City of Albuquerque Stormwater Construction Site Inspection Report

Project Name:	Defined Fitness @ Unser Crossings				
Location:	Unser & Centials - SW corner				
Site Contact Name & Agency	David Lopez- Guzman	ESC File No.	K10E045B		
	d.lopez@guzmanacs.com	NPDES Id. No.	NMR1001X7		
Inspection Date:	03/21/19	Start/End Time:	1030/1130hrs		
CoA Stormwater Inspector:	Timothy Sims, Stormwater Inspector				
Present Phase of Construction:	over ex., clear & grub				
Type of Inspection:	<input checked="" type="checkbox"/> Regular	<input type="checkbox"/> Storm Event	<input type="checkbox"/> Post Storm Event >0.25"	<input type="checkbox"/> 311/Complaint	<input type="checkbox"/> Follow Up

STABILIZED CONSTRUCTION ENTRANCE

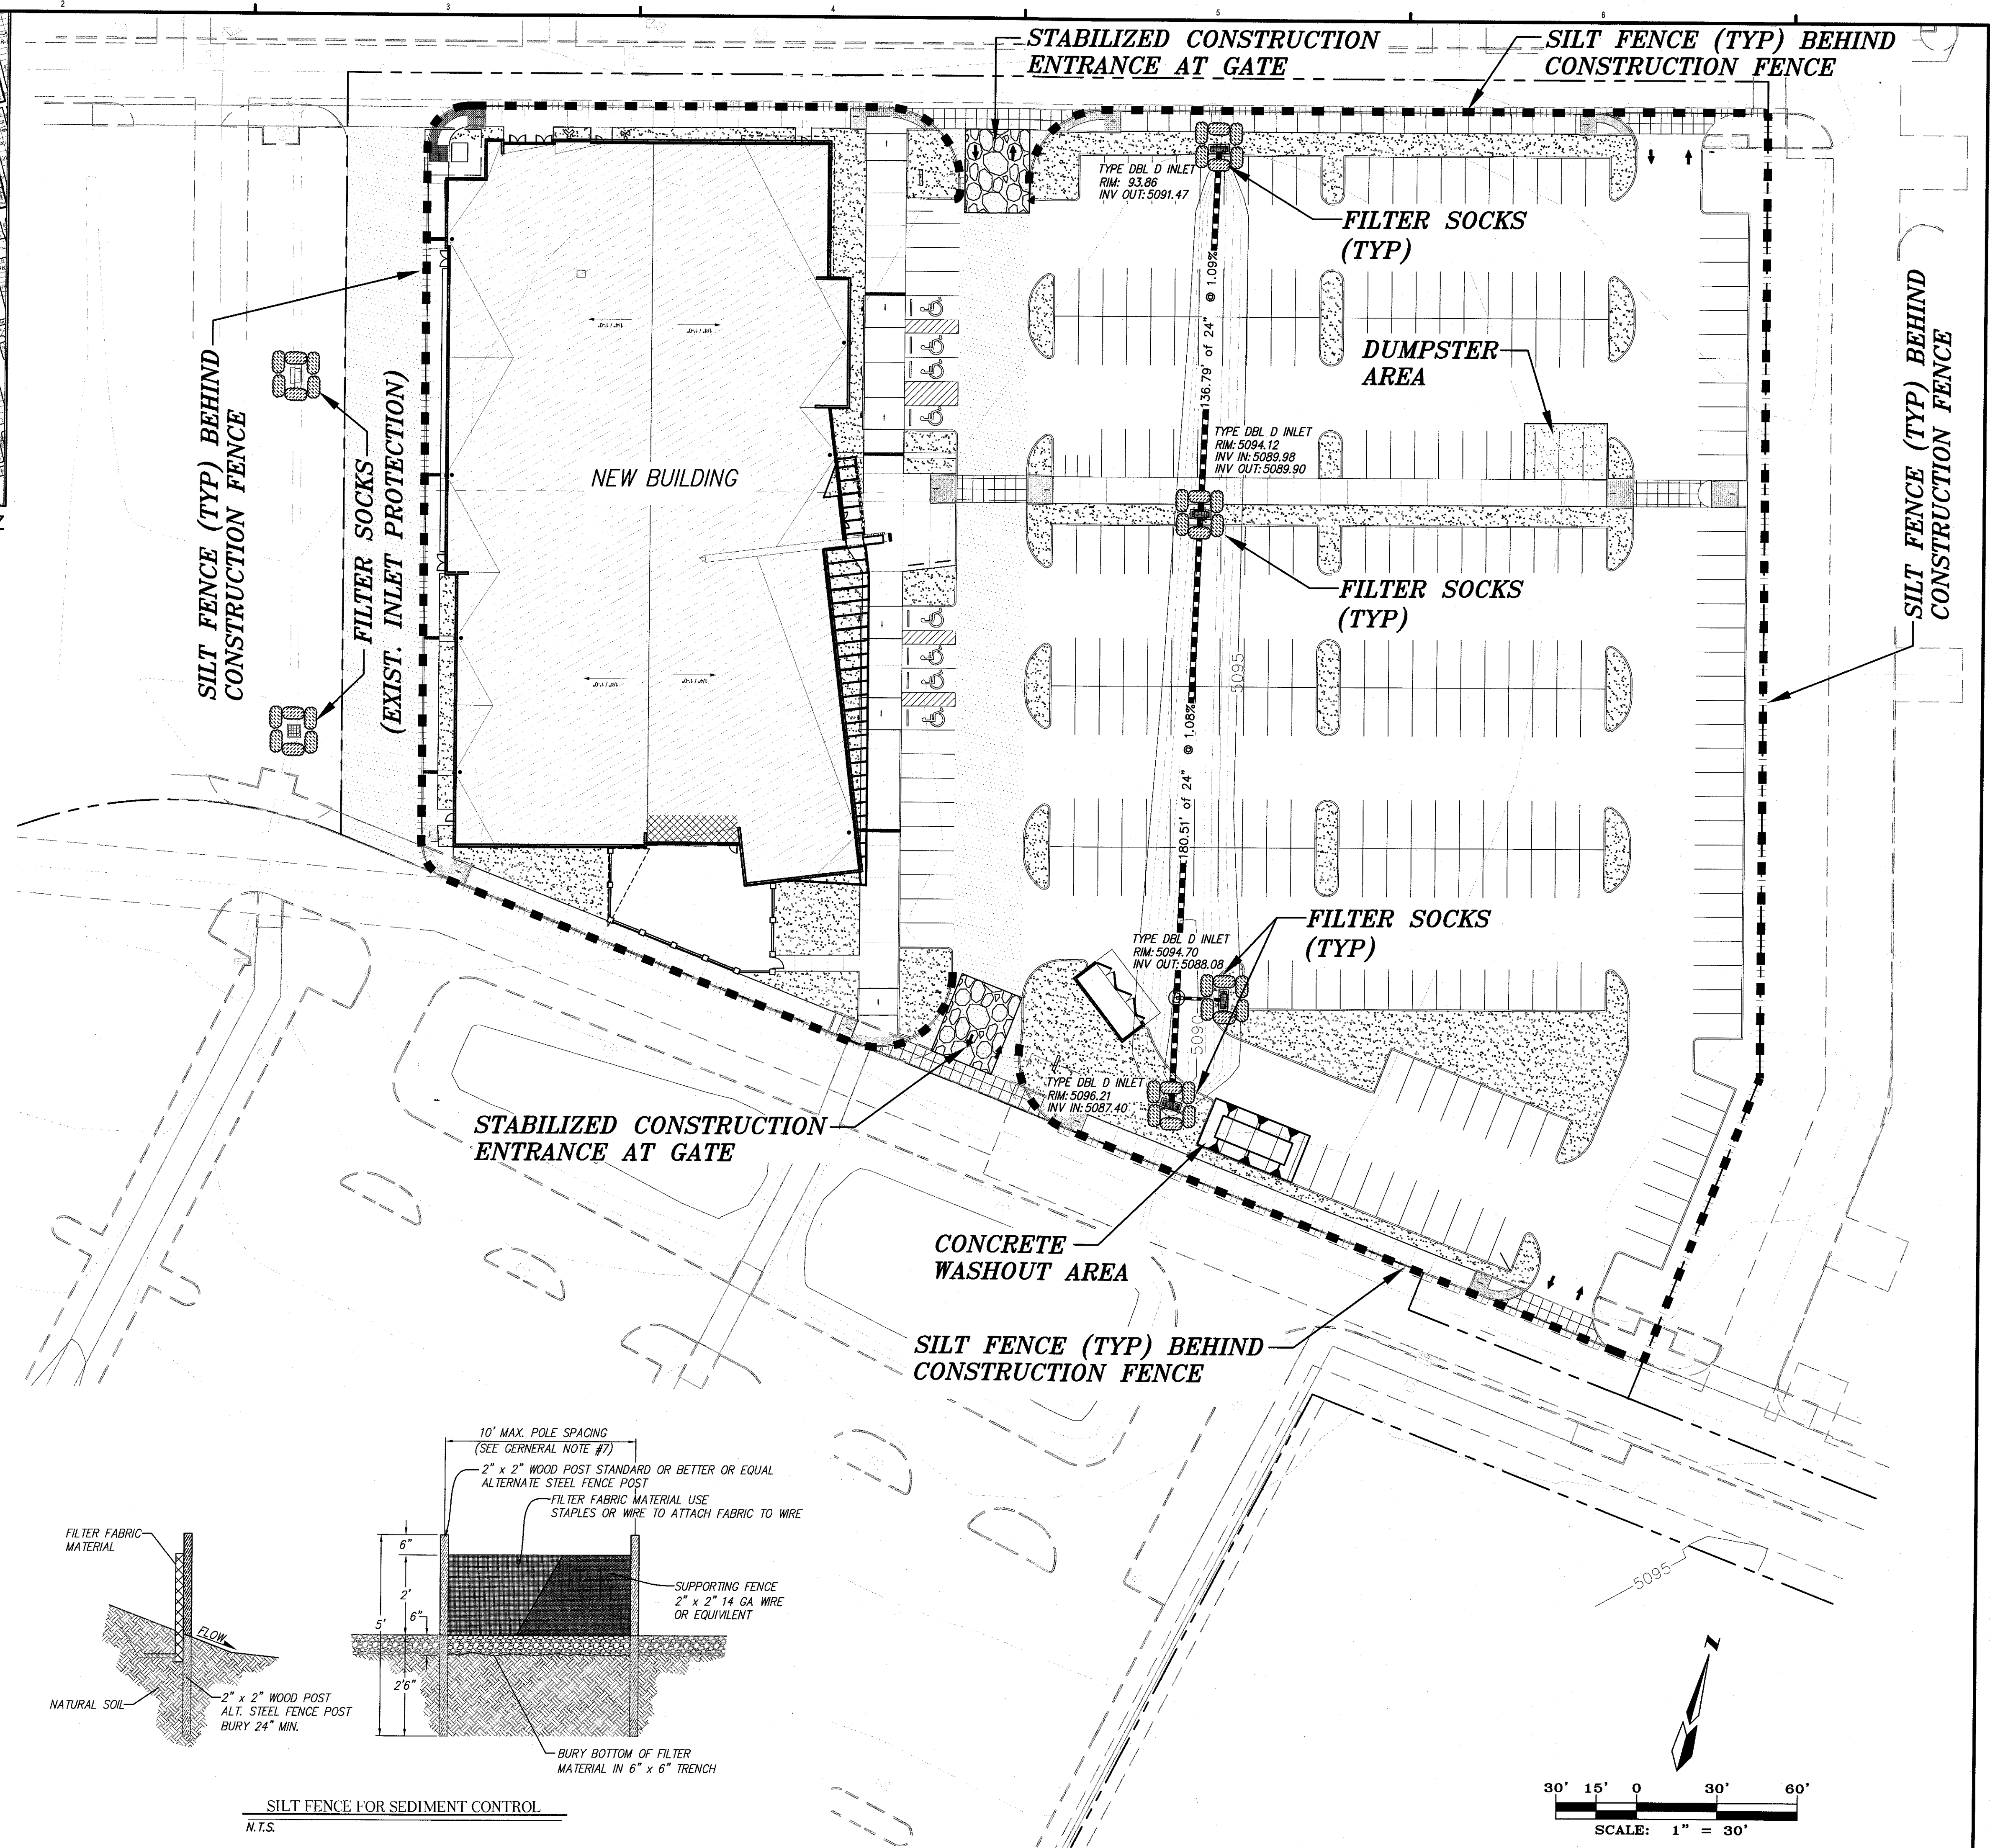
2.2.3	Sediment control along any perimeter	x	northern silt fence requiries maintenance
2.2.3	Sediment control along any perimeter	x	install track out pad/ sweep track out

2.2.4	Minimize sediment track out
